EPC STORMWATER REVIEW COMMENTS IN ORANGE BOXES WITH BLACK TEXT

GRADING AND EROSION CONTROL PLAN CHECKLIST
Retreat at TimberRidge Filing No. 4 (SF-1827)

RETREAT AT TIMBERIDGE FILING NO. 4
 CONSTRUCTION PLANS
 GRADING & EROSION CONTROL PLAN
 EROSION CONTROL DETAILS
 DESIGNED BY PRA SCALE DATE 2-29-24
 DRAWN BY PRA (H) 1"= N/A SHEET 4 OF 14
 CHECKED BY (V) 1"= N/A JOB NO. 1185.31

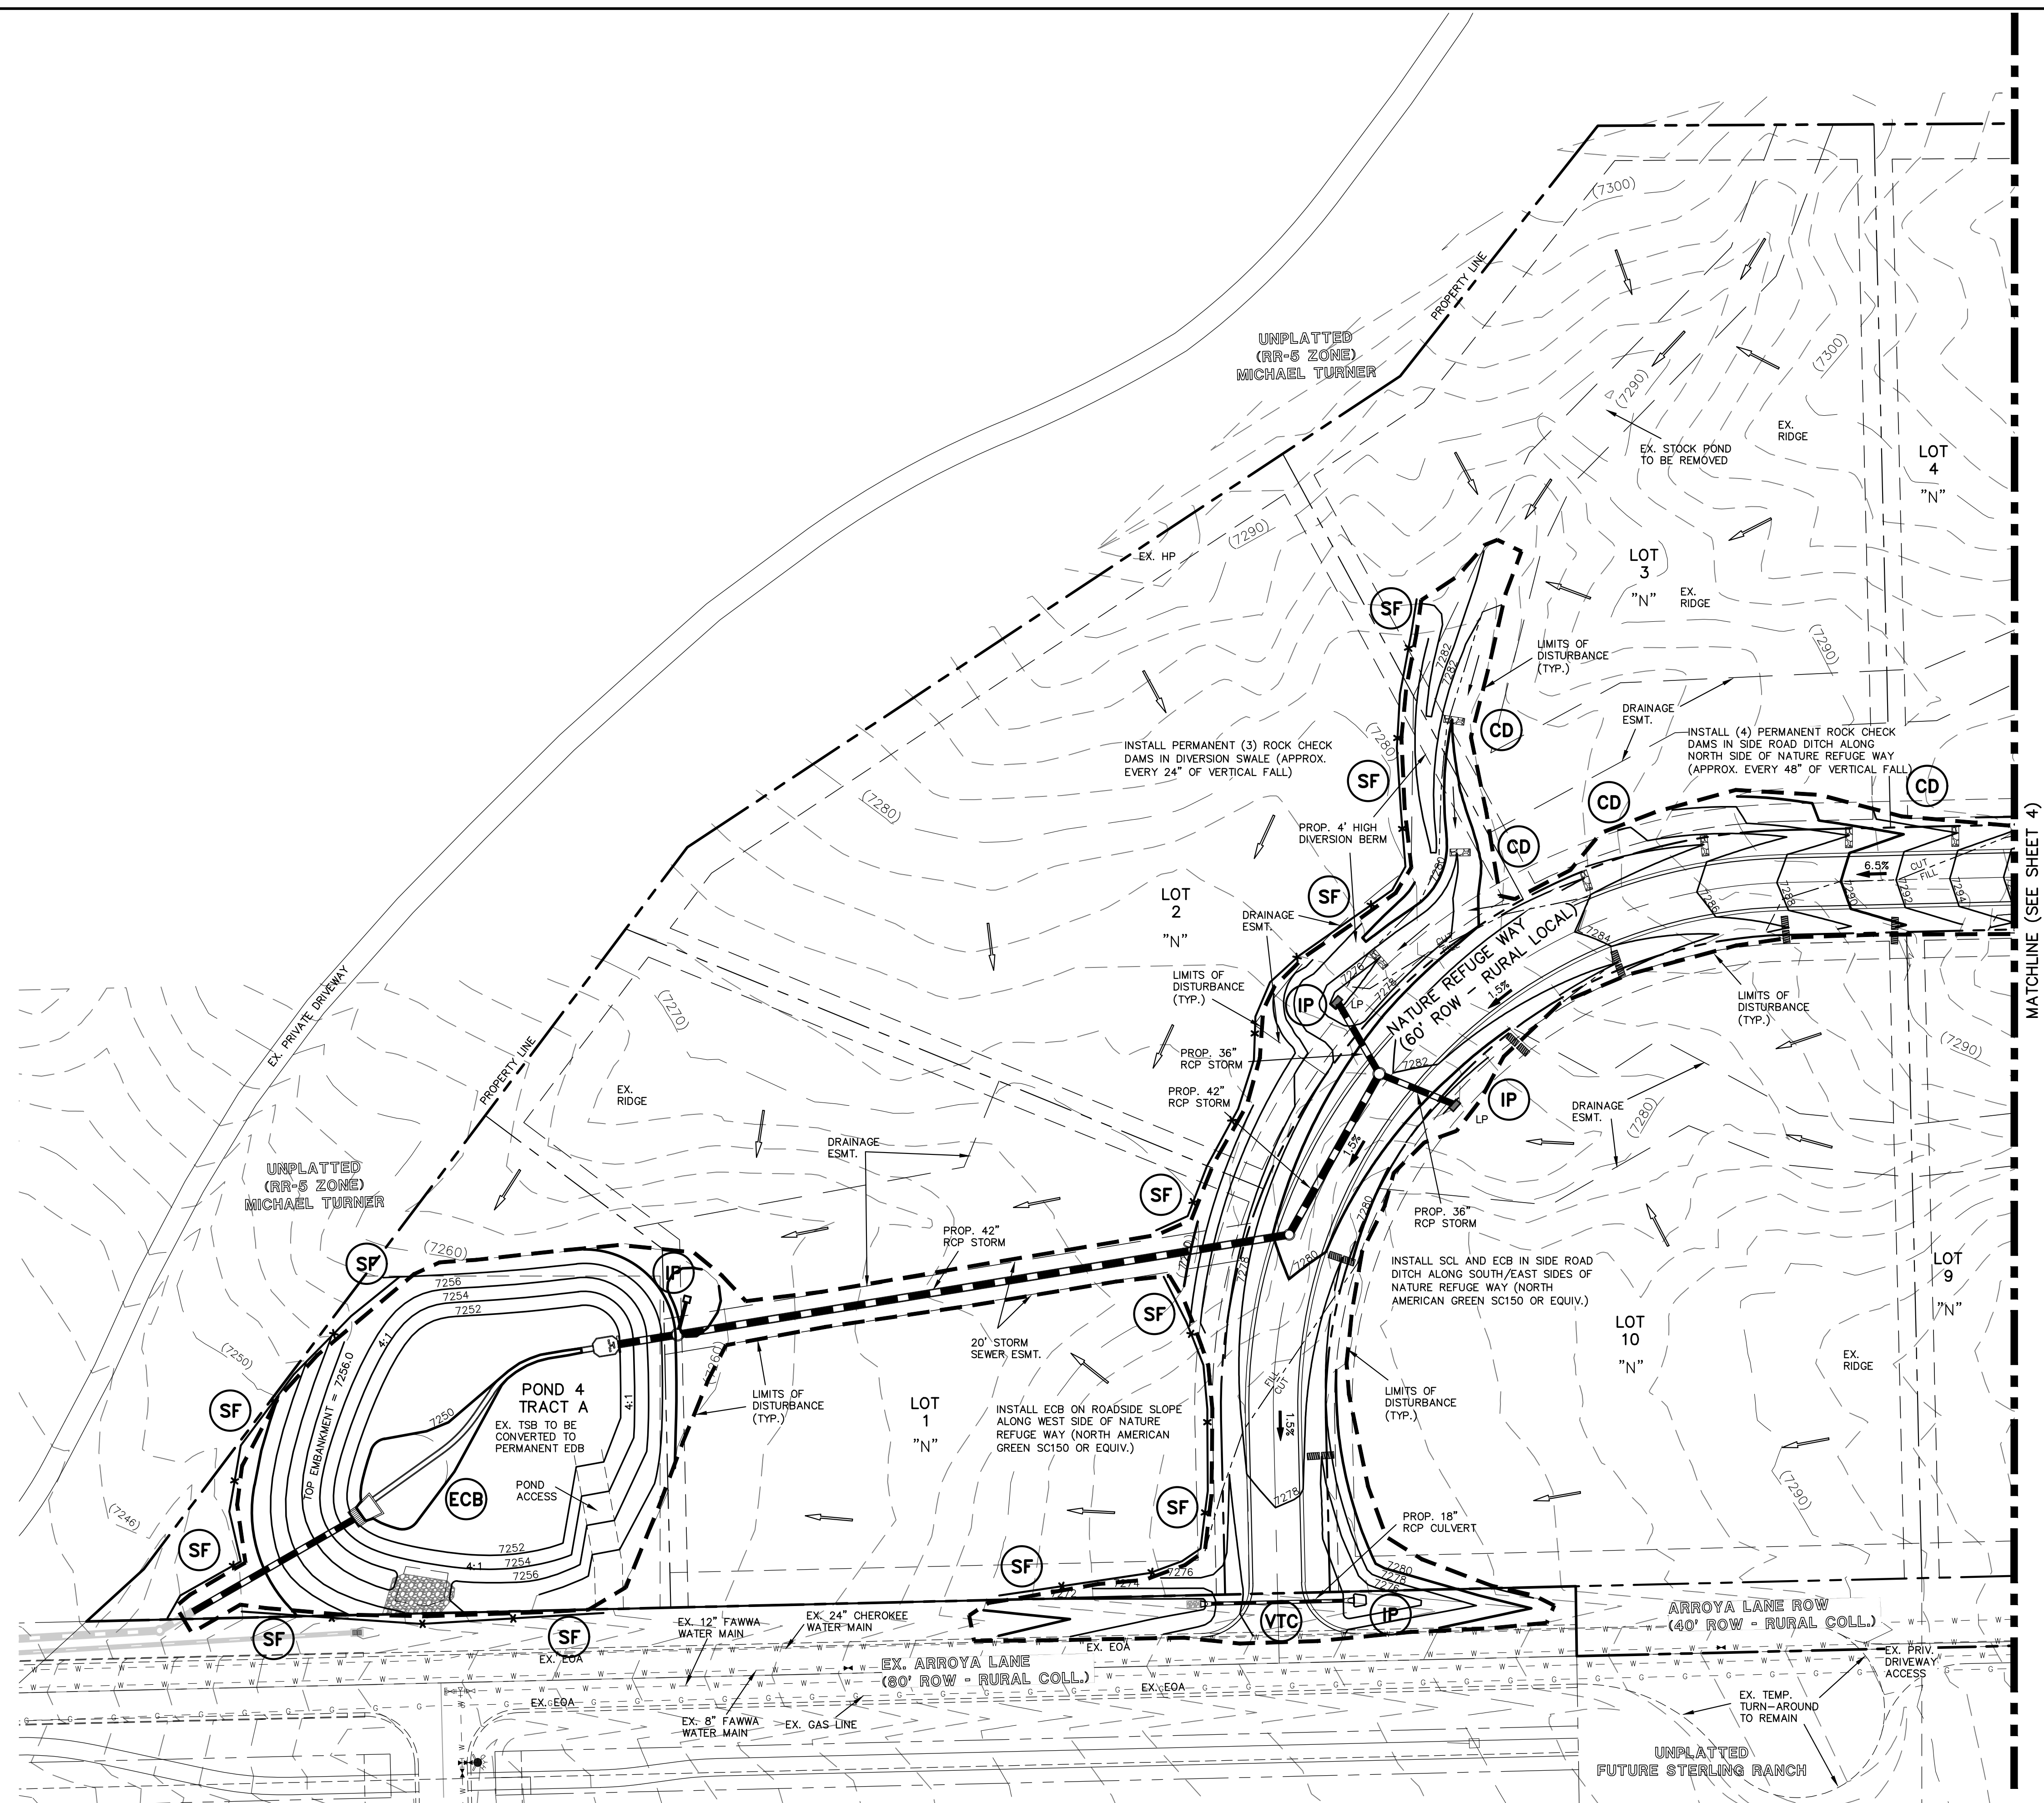
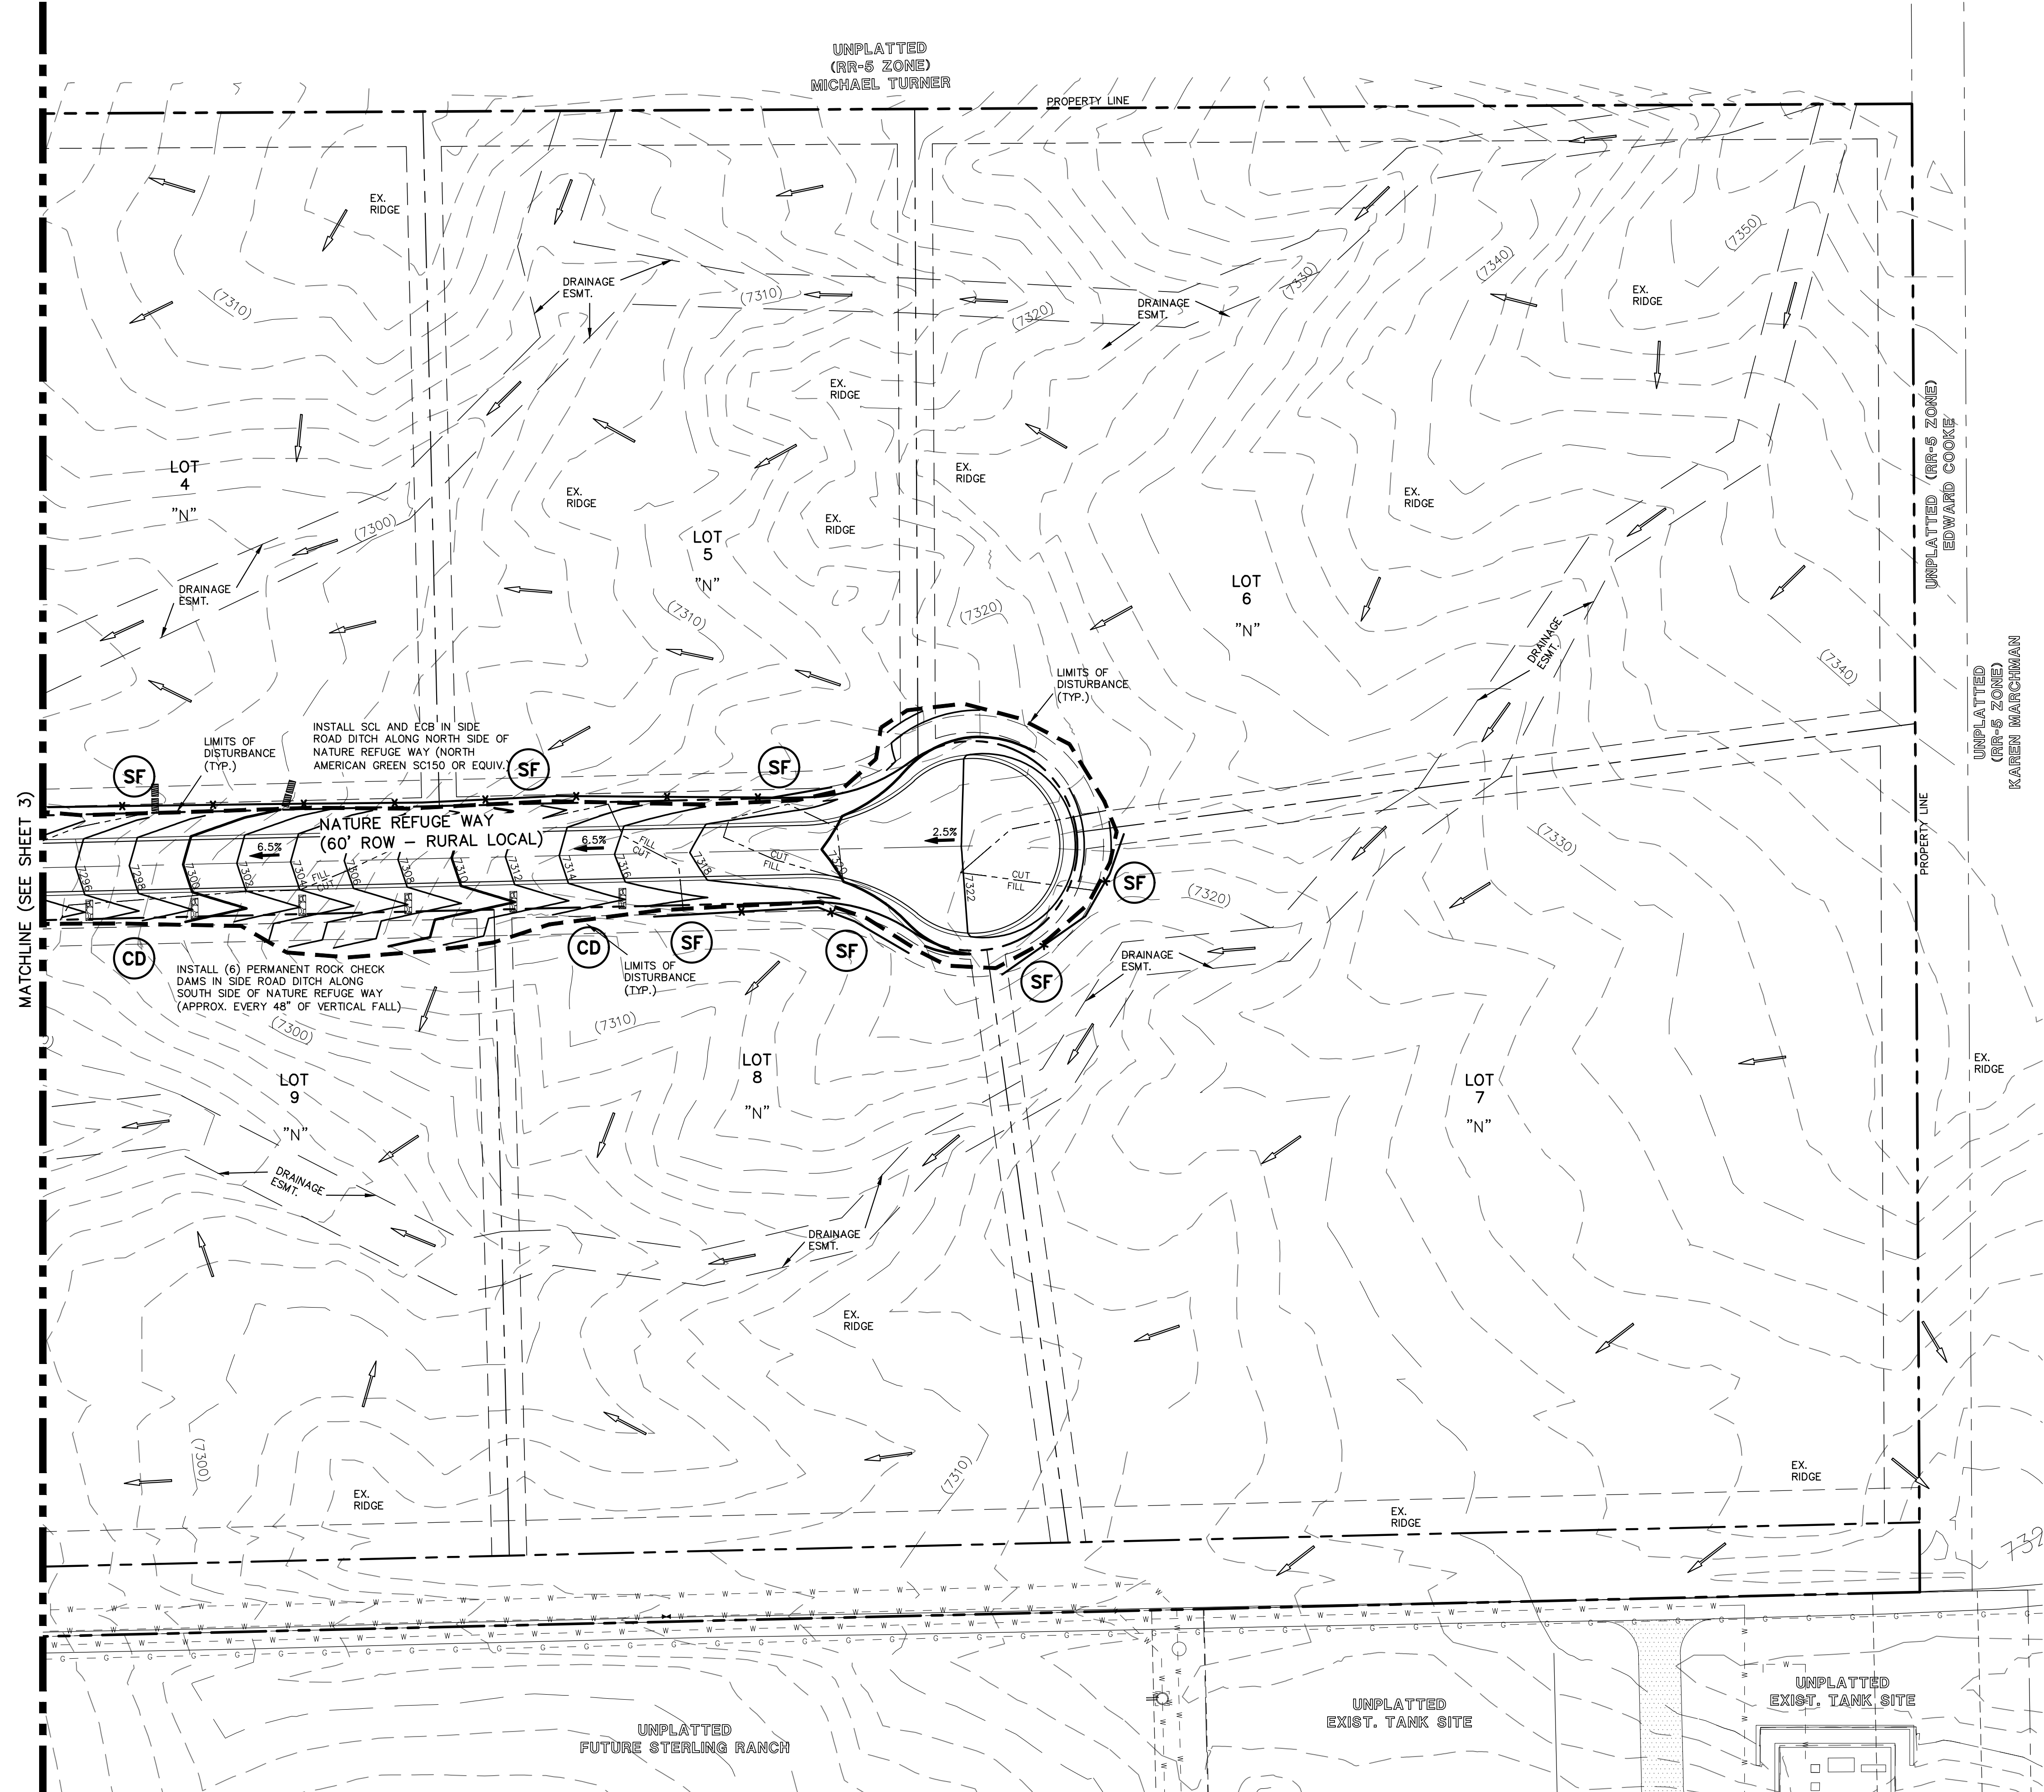
v	All proposed temporary construction control measures, structural and non-structural. Temporary construction control measures shall be identified by phase of implementation to include "initial," "interim," and "final" or shown on separate phased maps identifying each phase.	X	N
w	Vehicle tracking provided at all construction entrances/exits. Construction fencing, barricade, signage provided at access points not to be used for construction. Revised	X	Y
x	Temporary sediment ponds provided for disturbed drainage areas greater than 1 acre.	X	Y
y	Dewatering operations to include locations of diversion, pump and discharge(s) as anticipated at time of design.	N/A	N/A
z	All proposed temporary construction control measure details. Custom or other jurisdiction's details used must meet or exceed EPC standards.	X	Y
